From: Nicola Moore on behalf of Planning.Responses
Sent: 22 July 2019 14:23
To: Planning Scanning
Subject: FW: Planning Consultation on: WA/59/19/PL

Engineers Comments Regarding Surface Water Drainage

APPLICATION NO: WA/59/19/PL

Description of Works: Provision of an additional 3 No. residential mobile homes. This application is a Departure from the Development Plan.

NB: surface water run-off
direct to ground soakaway

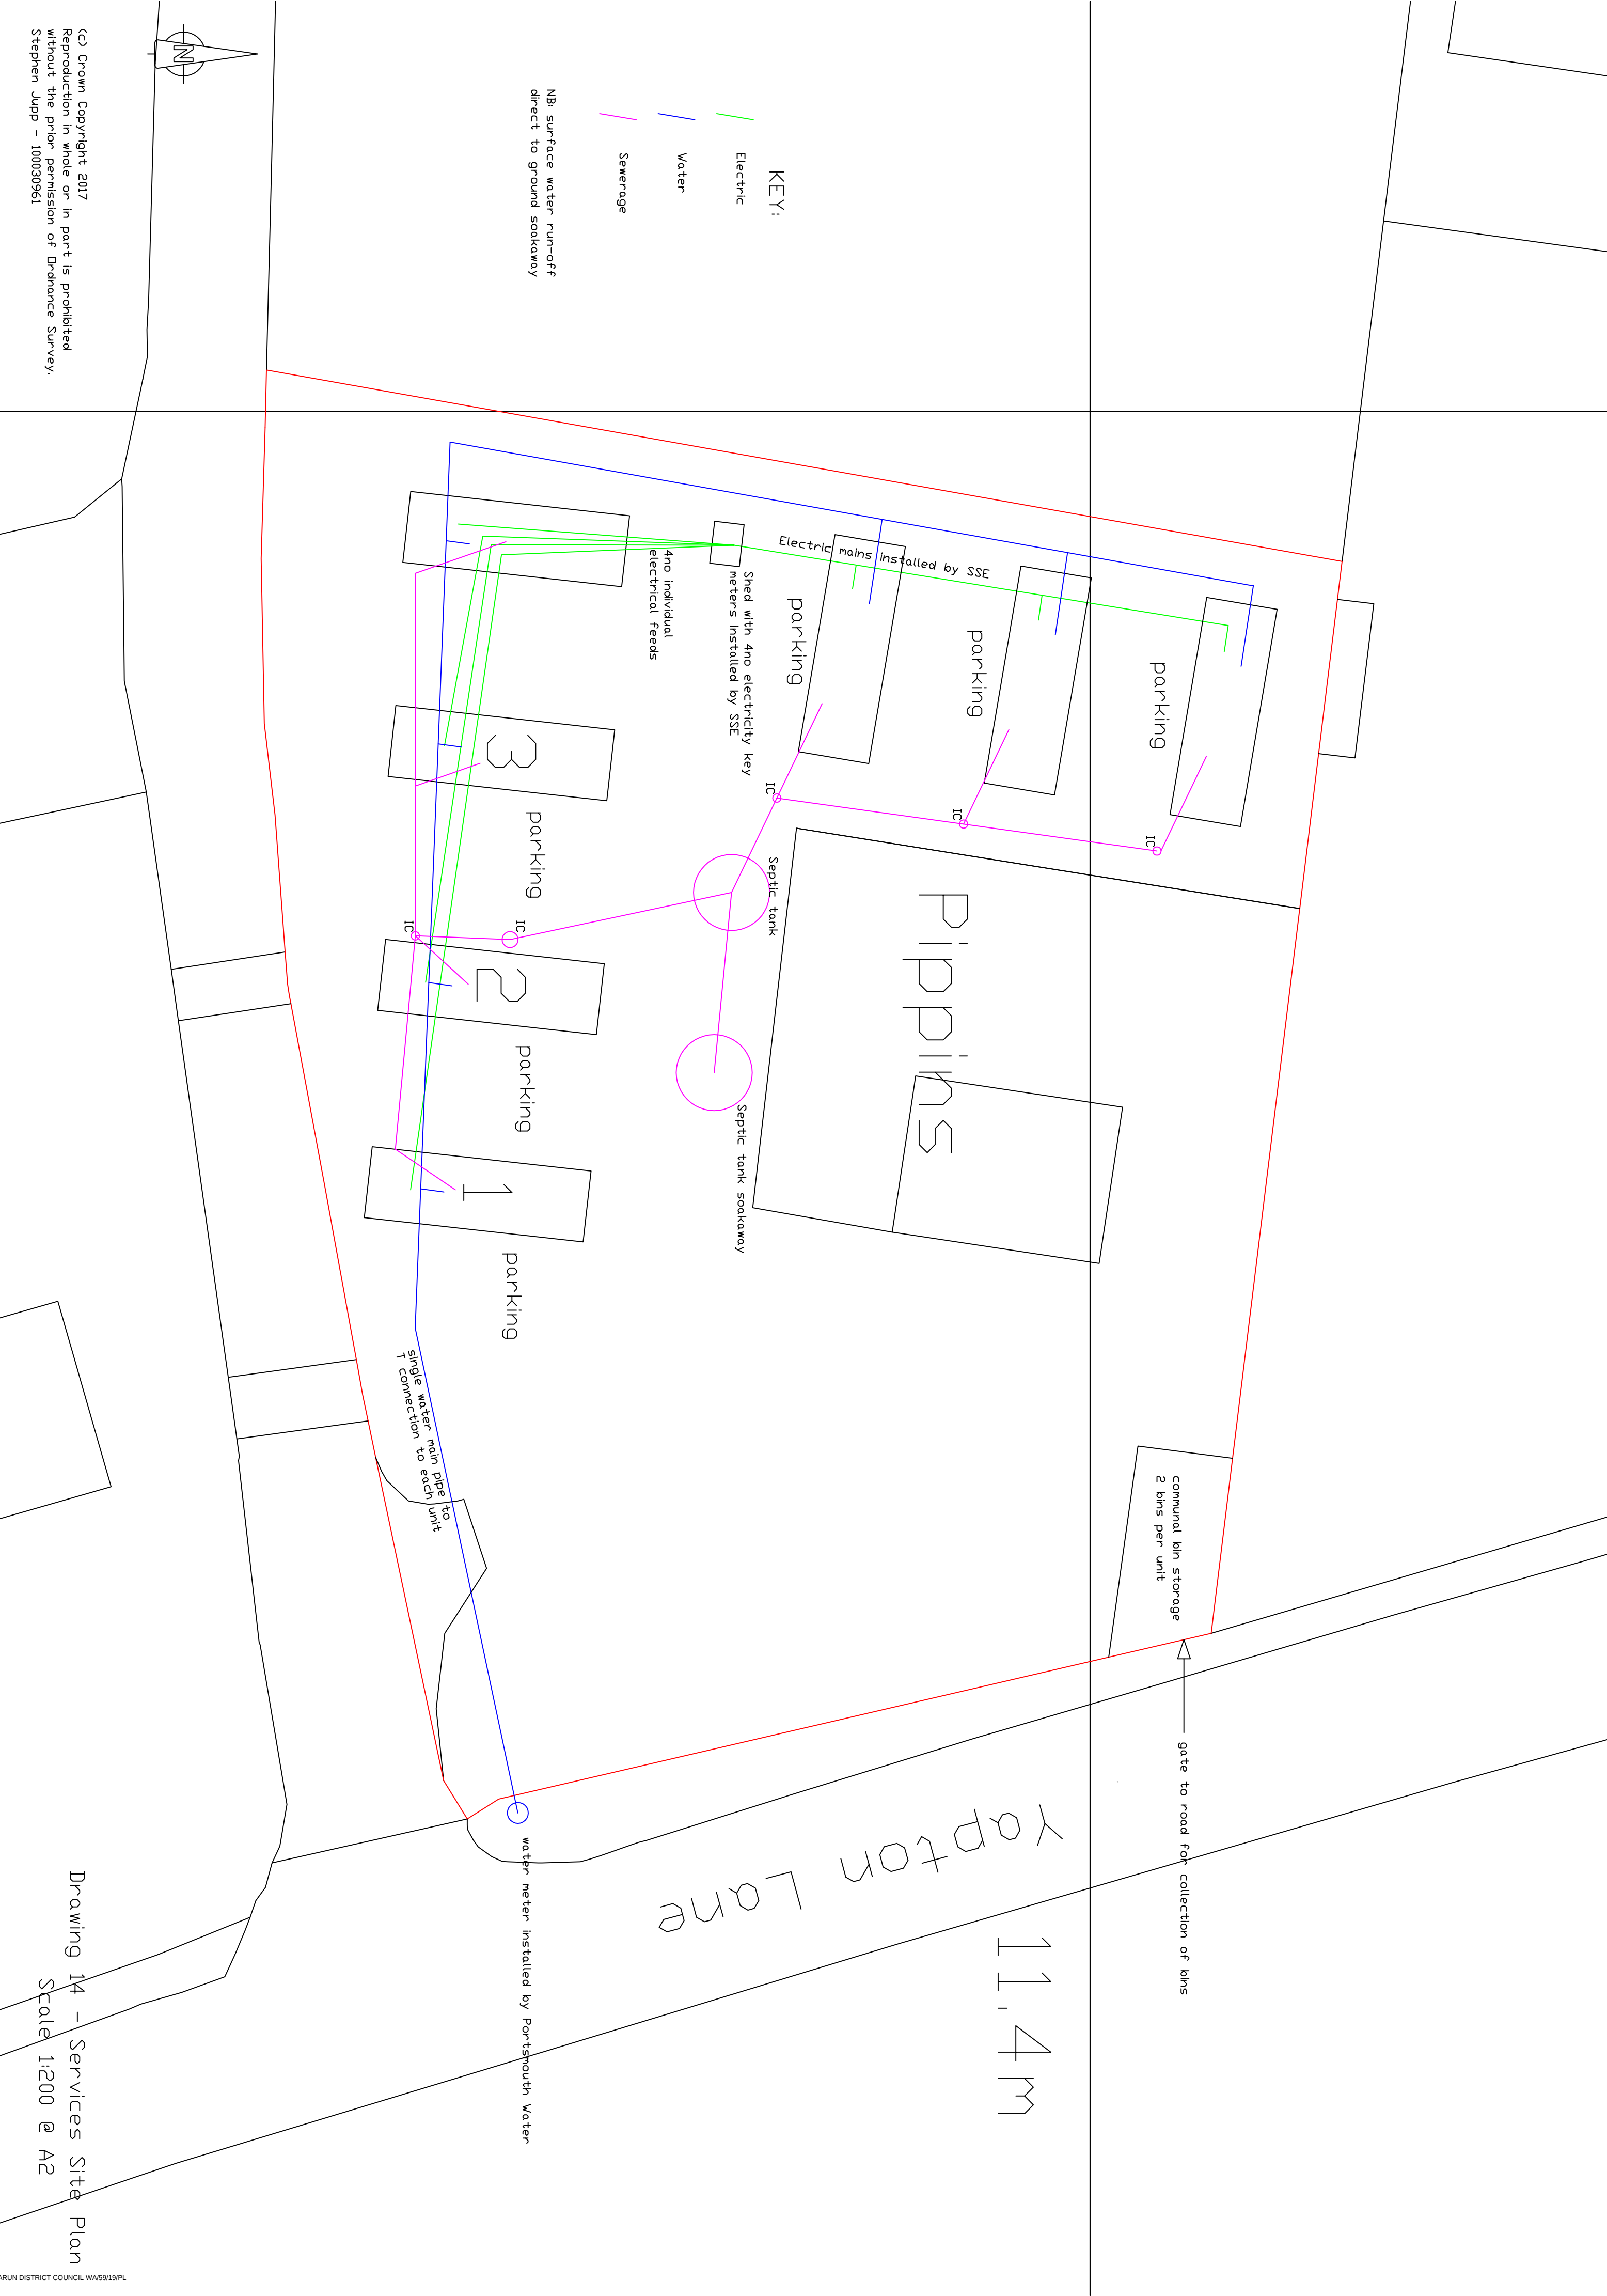
The application is within the Lidsey catchment and in an area of known high groundwater. As a result surface water drainage design should be carefully considered. Infiltration must be fully investigated.

"Development shall not commence, other than works of site survey and investigation, until full details of the proposed surface water drainage scheme have been submitted to and approved in writing by the Local Planning Authority. The design should follow the hierarchy of preference for different types of surface water drainage disposal systems as set out in Approved Document H of the Building Regulations, and the recommendations of the SuDS Manual produced by CIRIA. Winter groundwater monitoring to establish highest annual ground water levels and winter Percolation testing to BRE 365, or similar approved, will be required to support the design of any infiltration drainage. No building / No part of the extended building shall be occupied until the complete surface water drainage system serving the property has been implemented in accordance with the agreed details and the details so agreed shall be maintained in good working order in perpetuity."

"Infiltration rates for soakage structures are to be based on percolation tests undertaken in the winter period and at the location and depth of the proposed structures. The percolation tests must be carried out in accordance with BRE365, CIRIA R156 or a similar approved method and cater for the 1 in 10 year storm between the invert of the entry pipe to the soakaway, and the base of the structure. It must also have provision to ensure that there is capacity in the system to contain below ground level the 1 in 100 year event plus 40% on stored volumes, as an allowance for climate change. Adequate freeboard must be provided between the base of the soakaway structure and the highest recorded annual groundwater level identified in that location. Any SuDS or soakaway design must include adequate groundwater monitoring data to determine the highest winter groundwater table in support of the design. The applicant is advised to discuss the extent of groundwater monitoring with the Council's Engineers.
